HOMESTEAD NORTH AT STERLING RANCH FILING NO. 1

COUNTY OF EL PASO, STATE OF COLORADO GRADING AND EROSION CONTROL PLANS NOVEMBER, 2021

PCD FILING NO.: SP-20-008

Engineering Review

COVER SHEET

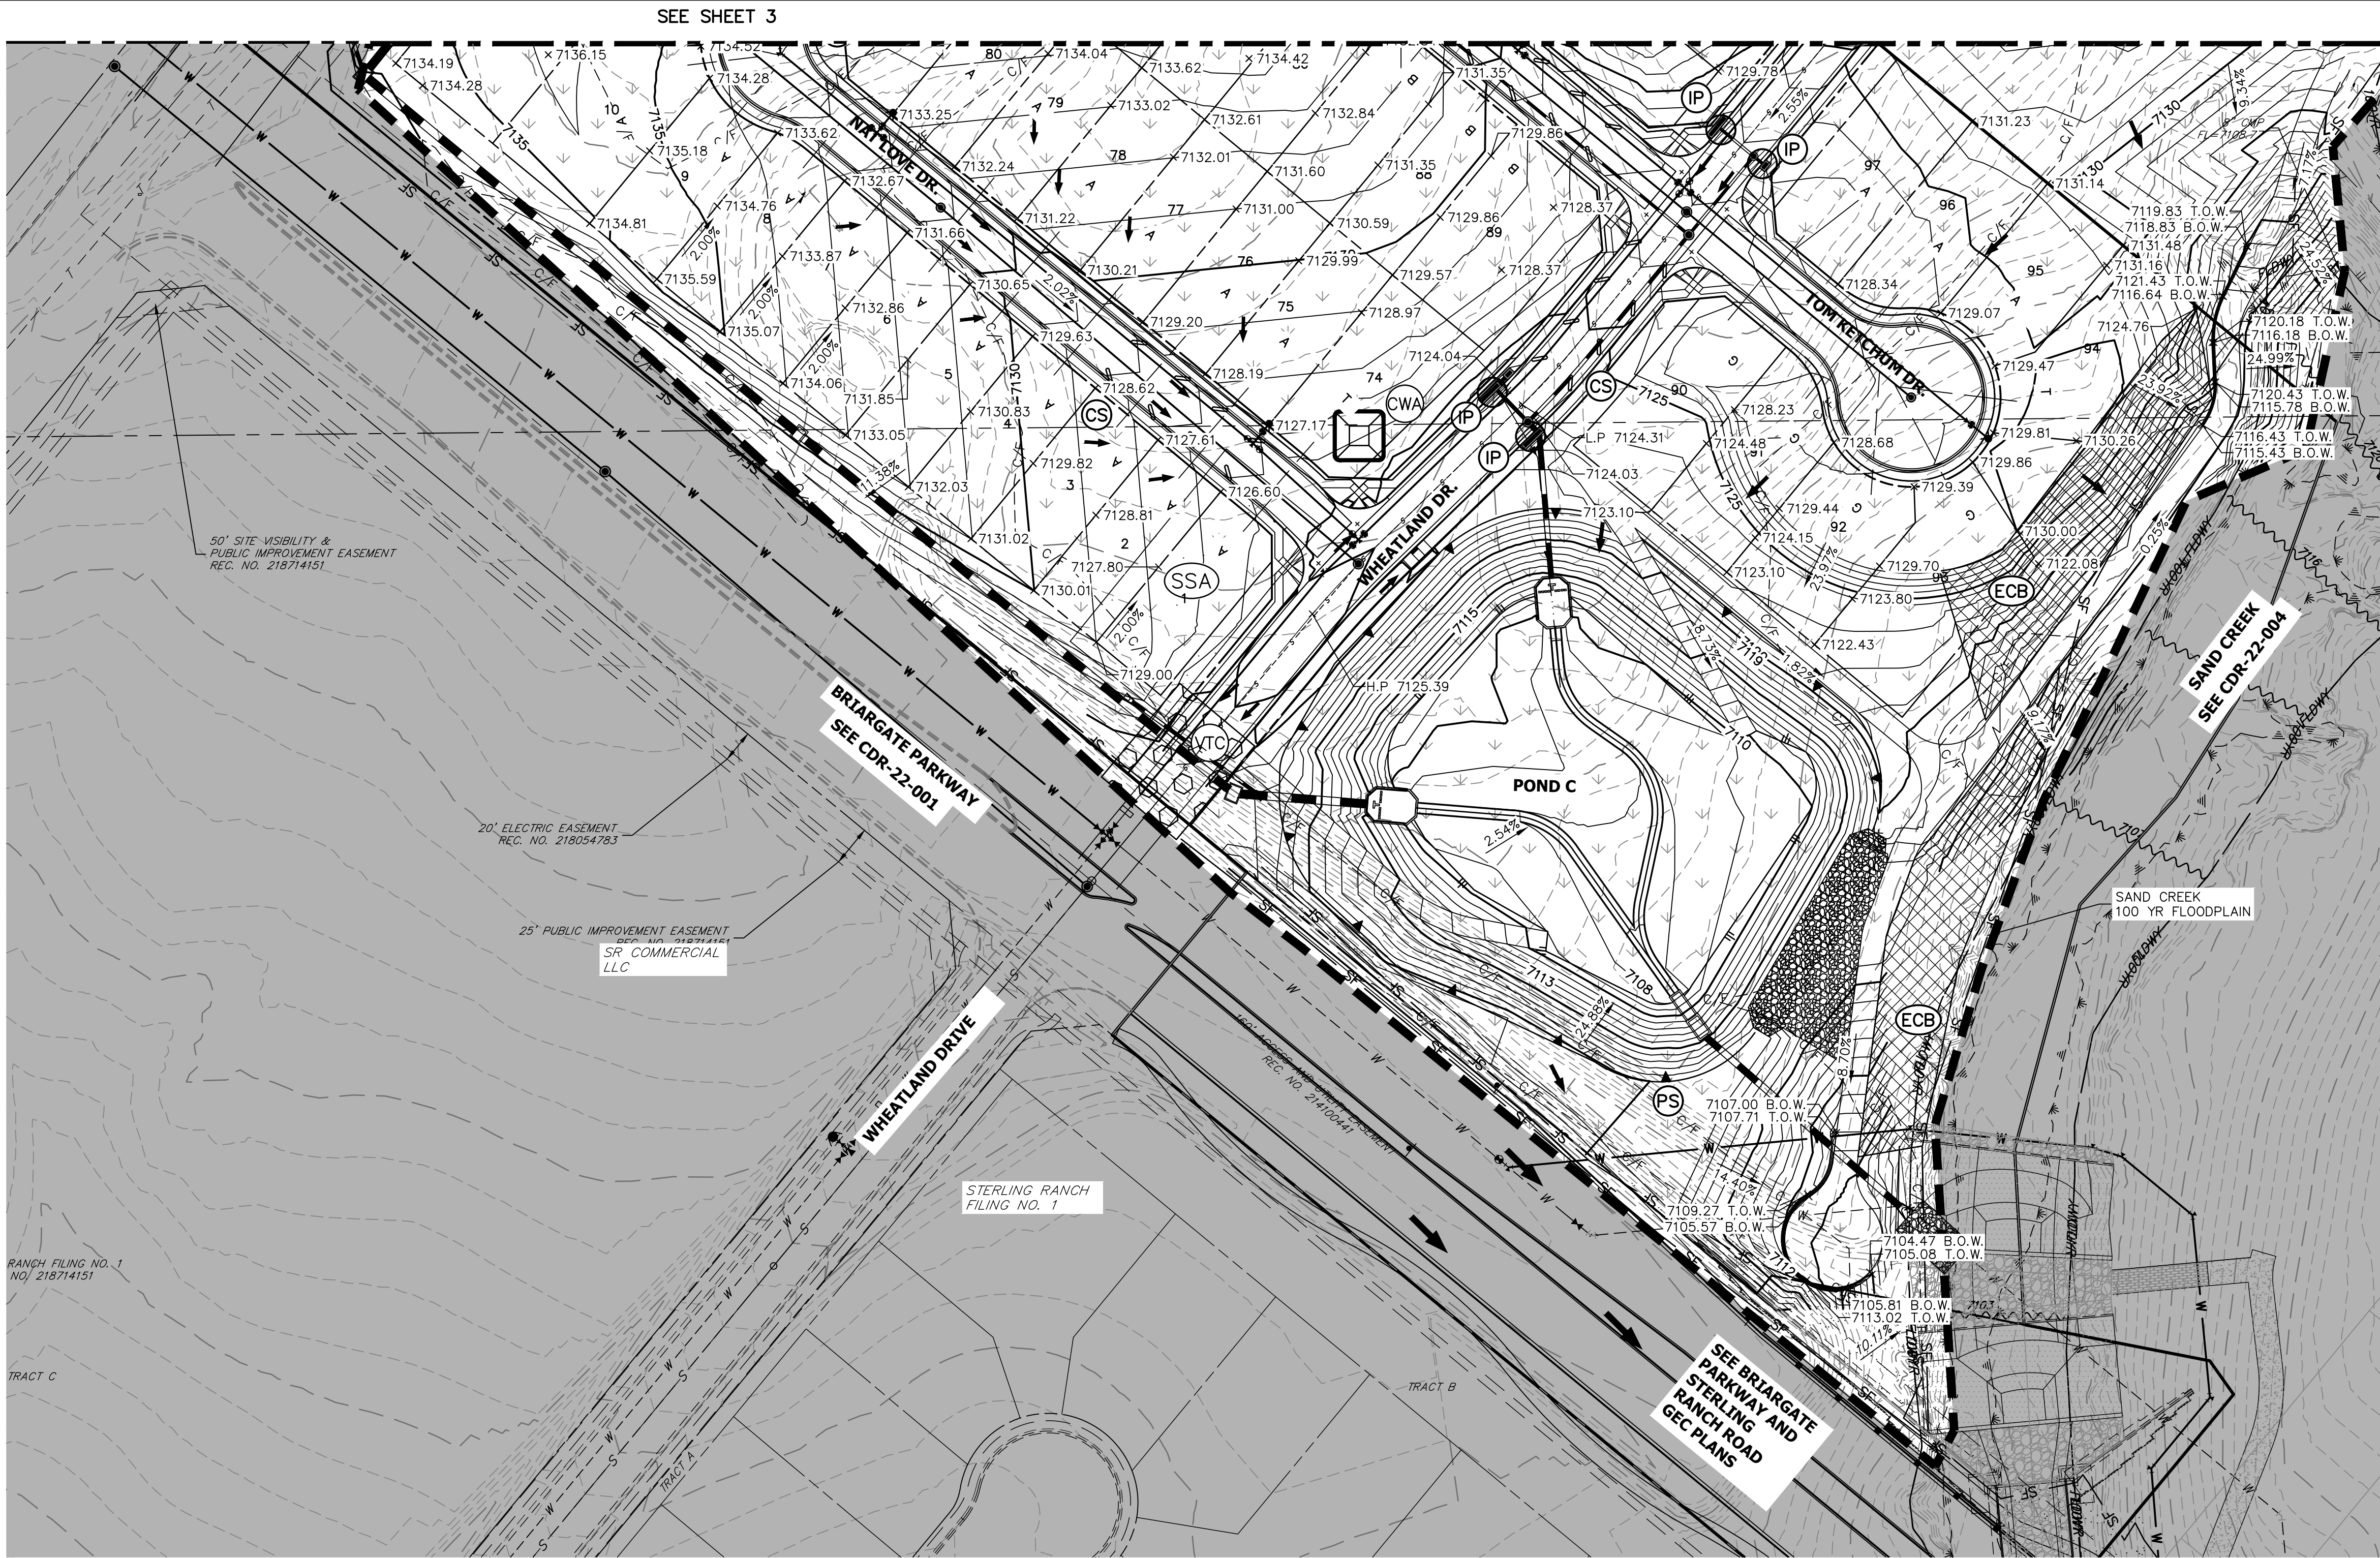
If the arrows are intended for lot line swales to be constructed by builders please use a different symbol.

Correct all drainage flow arrows to be more perpendicular to contours

If this is a final grading plan all proposed lots, features and utilities need to be shown
